From:
Sent: 06 July 2026 12:24
To: Katie Chew
Cc: DC Admin
Subject: Clarification required regarding application 2026/91657

I am writing regarding application **2026/91657** for Plot 23.

The application appears to be described as adding a double garage. However, the submitted drawing **SK15 Rev B** appears to show other matters as well.

Front elevation (1:100)

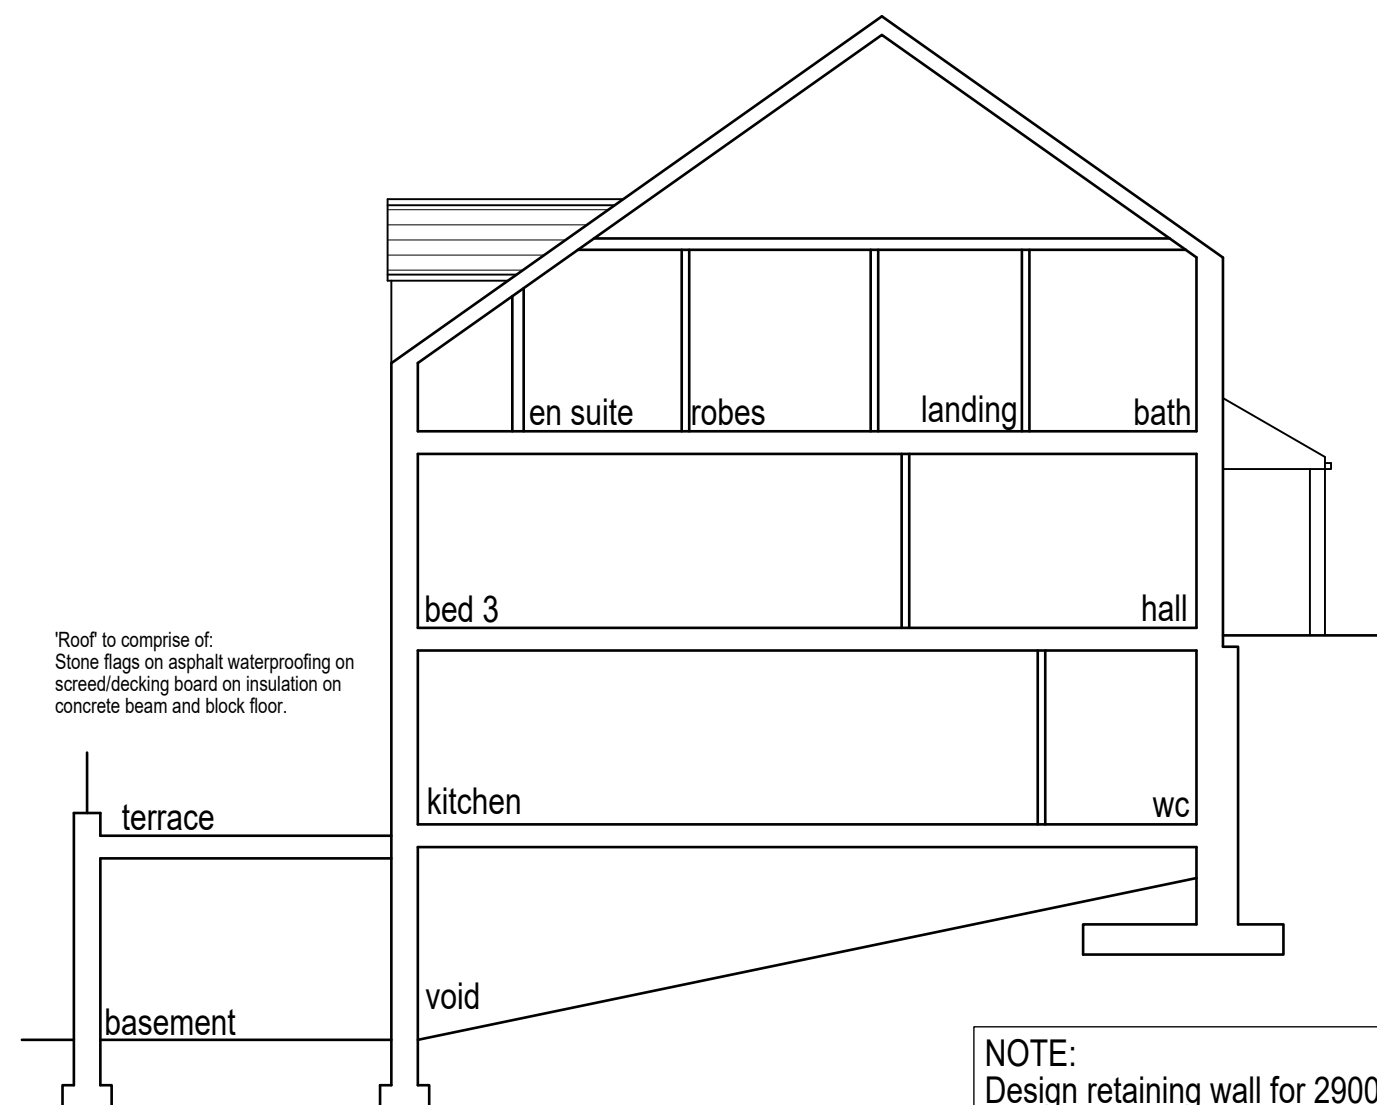
1. a **garage-only amendment**; or
2. an application to approve **everything shown on SK15 Rev B**, including any non-garage changes?

This clarification is important because, if SK15 Rev B is approved under Condition 2, I am concerned that all changes shown on that drawing may be treated as approved, not just the garage.
